Himley Village, Bicester

Phase 1B, Road Safety Audit - Stage 1 Designer's Response

Date 24 May 2024

Doc ref 27141-HYD-XX-XX-RP-C-0002-P01

REFER TO KEY PLAN FOR EXTRACT LOCATIONS

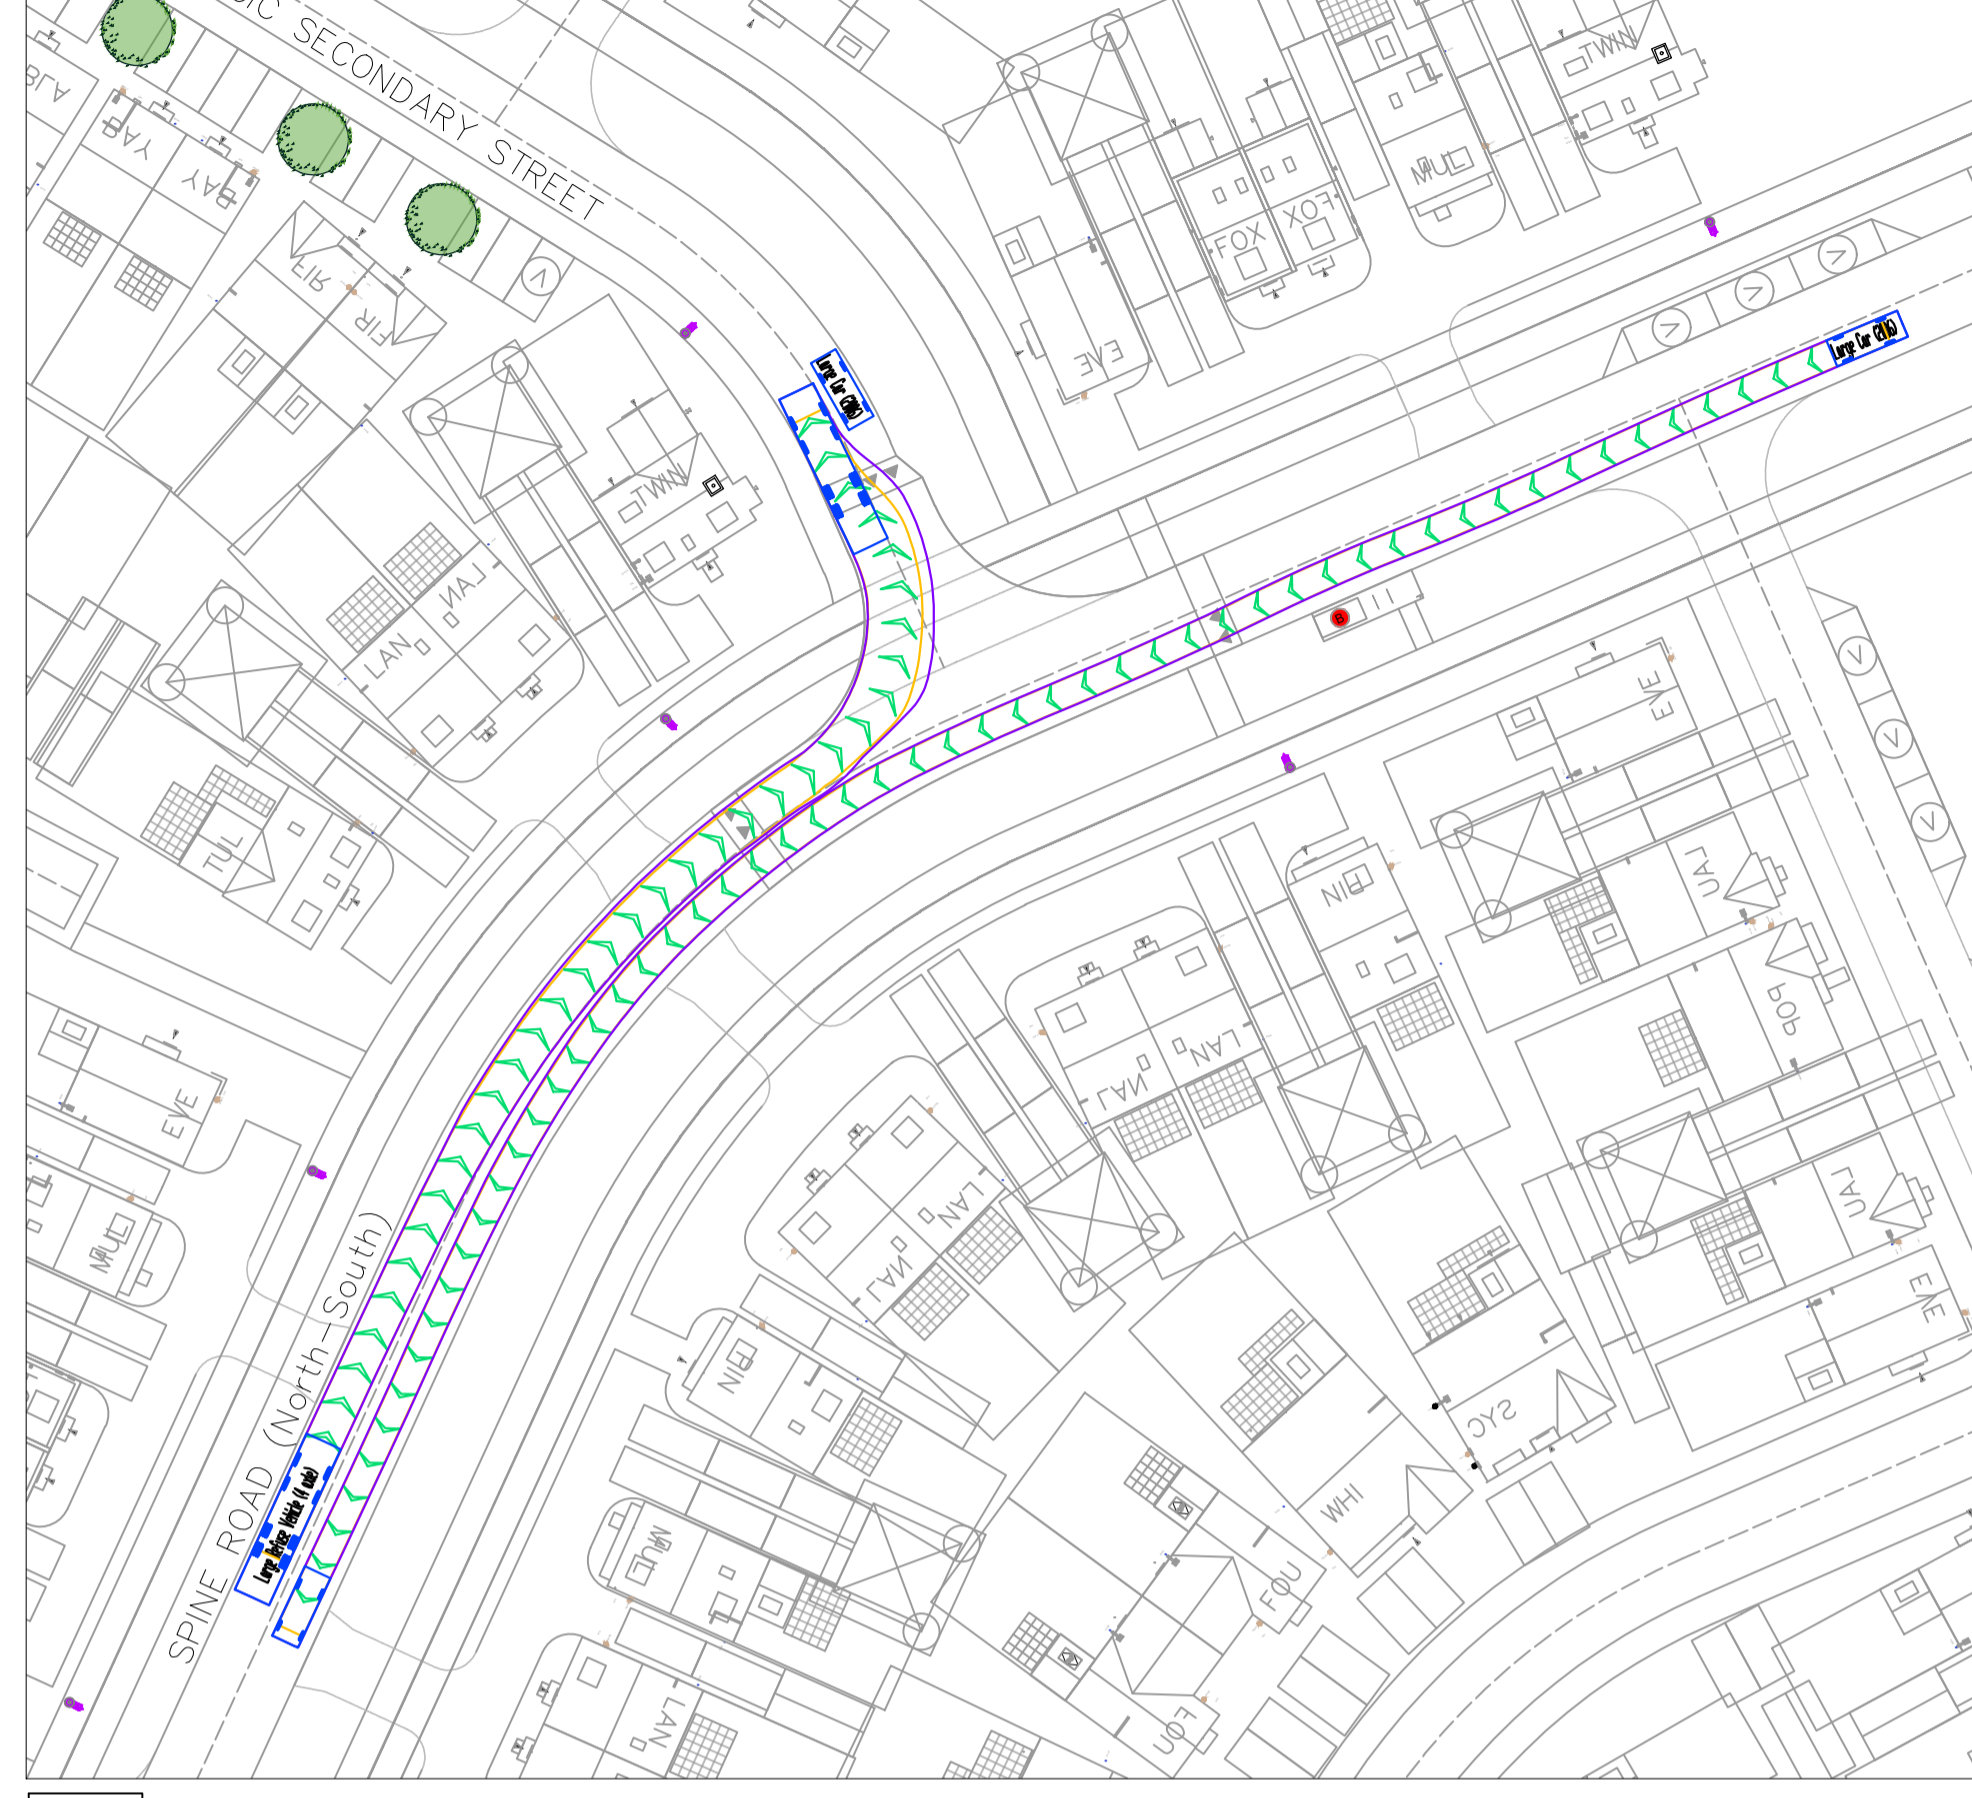
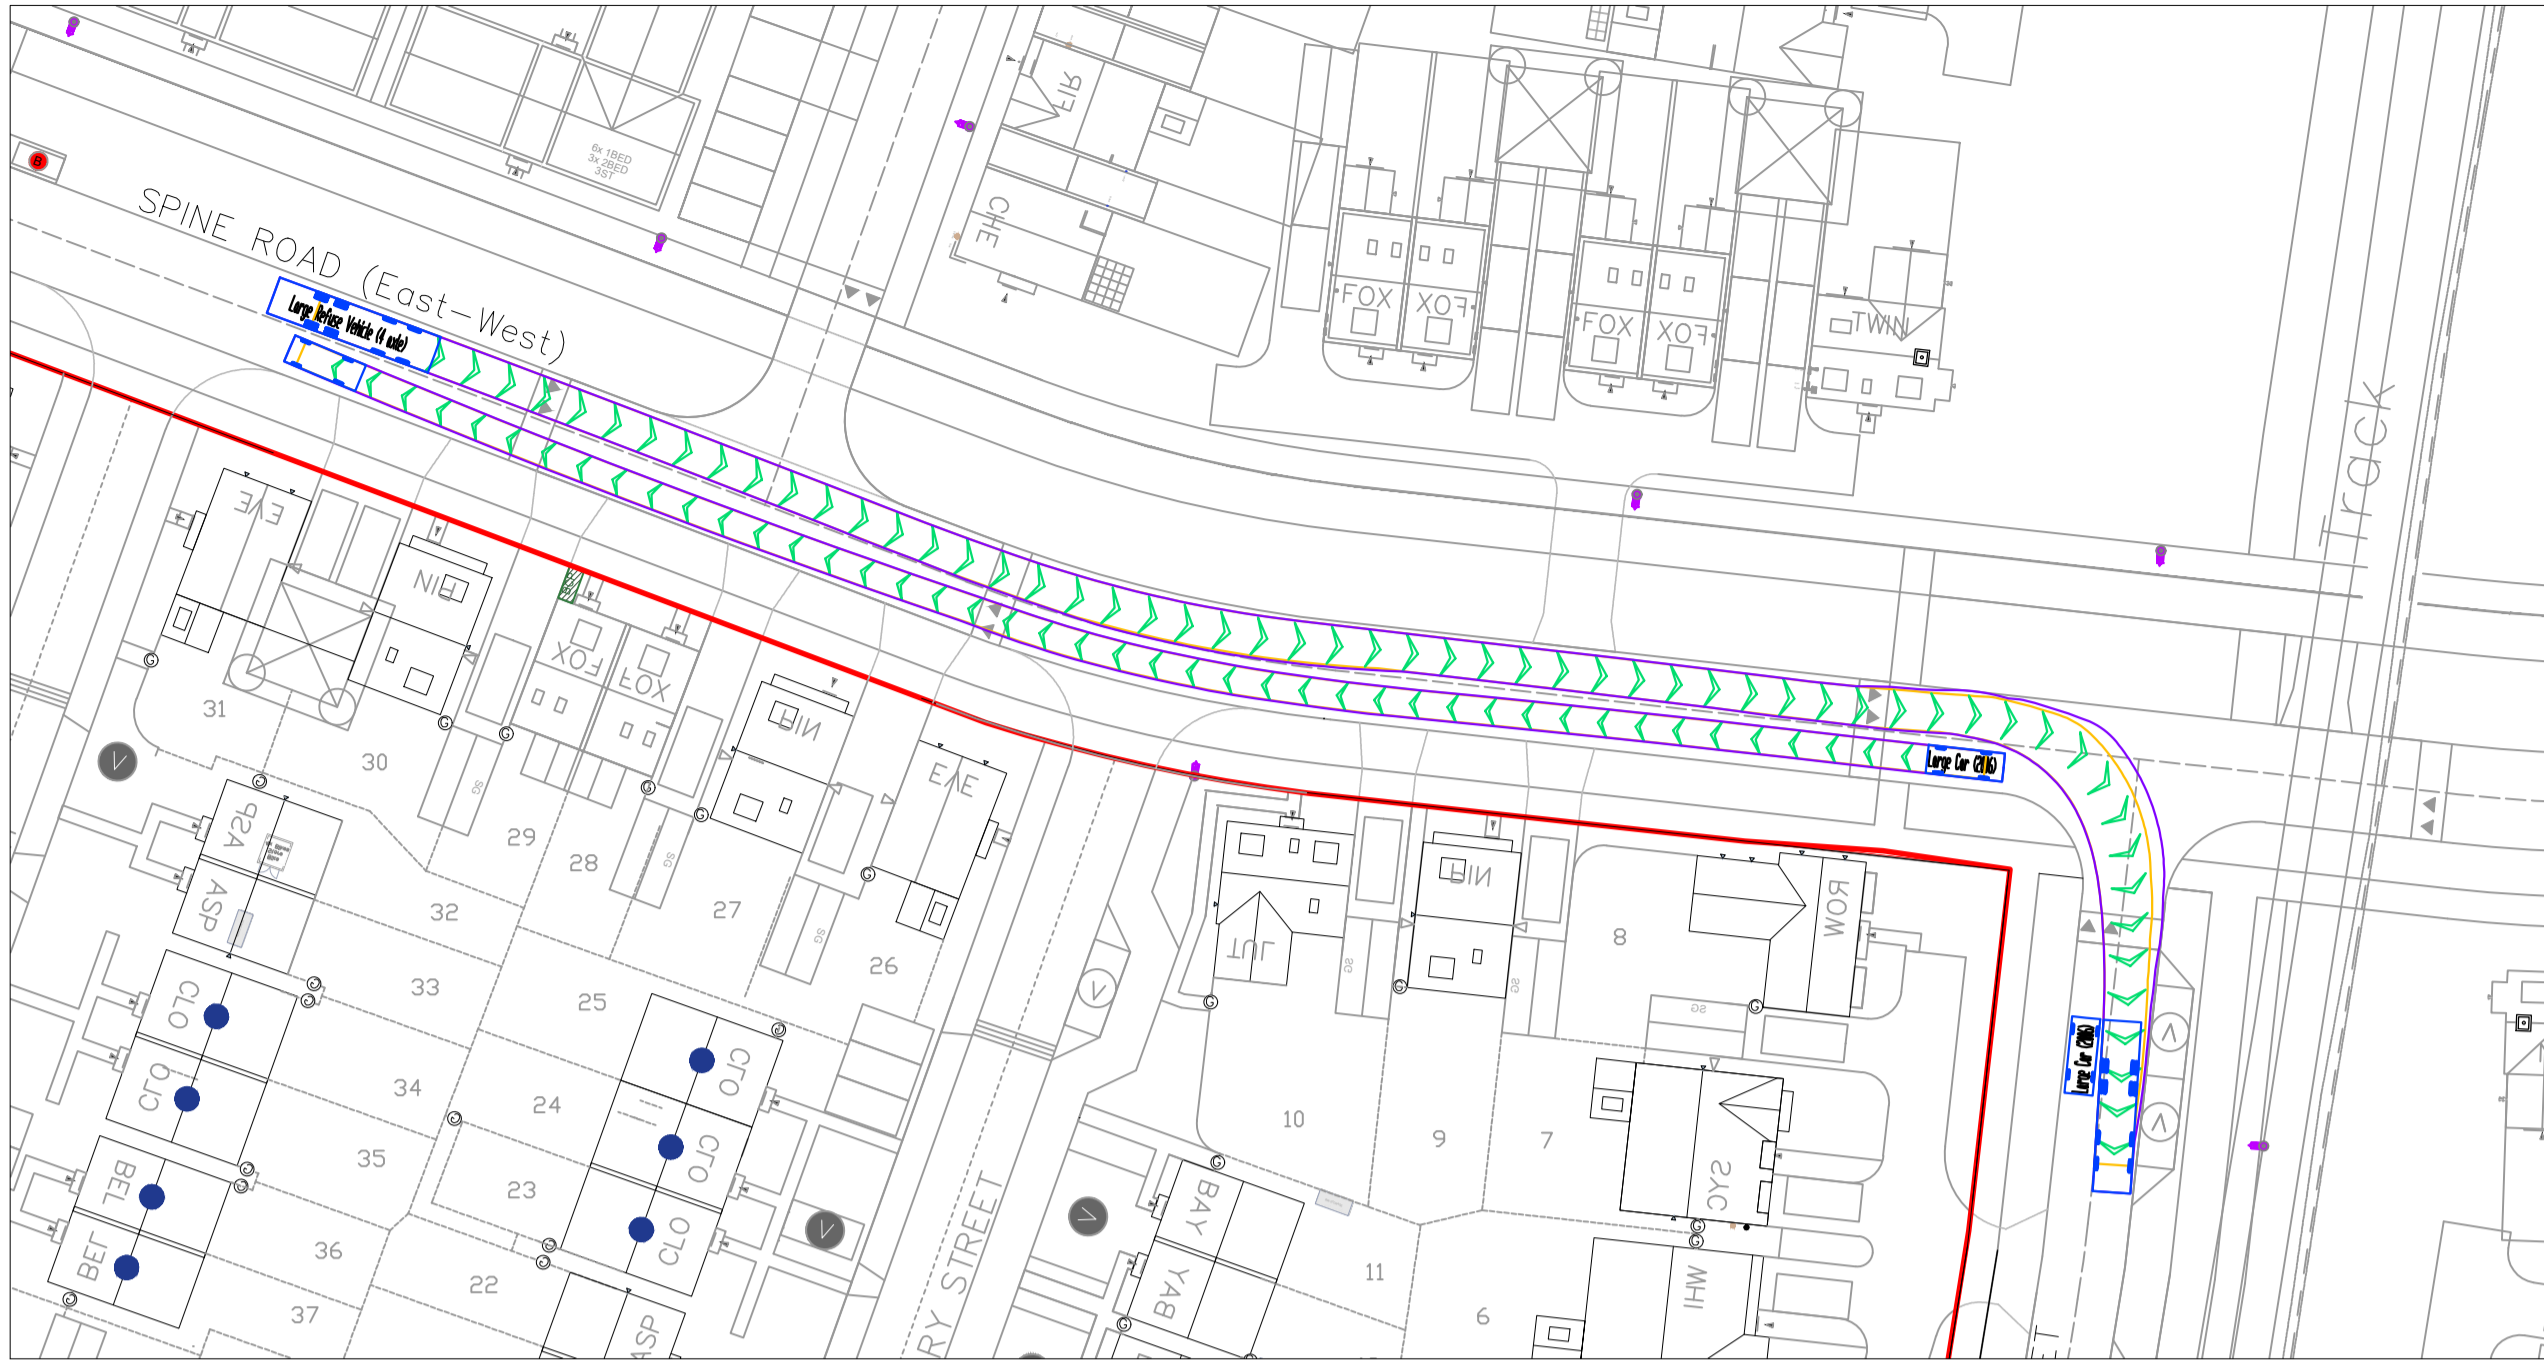
From the vehicle swept path analysis provided as part of the scheme submission, it is evident that larger service/refuse vehicle cannot turn left from the site without encroaching onto the right turn lane. Insufficient carriageway widths to accommodate long wheel based vehicular turning movements may increase the risk of vehicle on vehicle side impact/sideswipe type collisions.

RSA Ref No.	RSA Problem	RSA Recommendation	Design Organisation Response	Overseeing Organisation Response
3.4	Middleton Stoney Road – Vehicular Access Eastern end From the vehicle swept path analysis provided as part of the scheme submission, it is evident that larger service/refuse vehicle cannot turn left from the site without encroaching onto the right turn lane. Insufficient carriageway widths to accommodate long wheel based vehicular turning movements may increase the risk of vehicle on vehicle side impact/sideswipe type collisions.	The Audit Team recommends providing adequate carriageway geometry to ensure that all likely vehicle types to use this junction can carry out turning safely and without obstruction.	DISAGREE: The eastern site access is the secondary access onto a 5.5m road into the site; providing tapers within the area increases the size of the minor junction, which should primarily be used by cars. The only HGVs using the access should be the occasional refuse vehicle. HGVs typically encroach on the adjacent lanes, when exiting minor junctions.
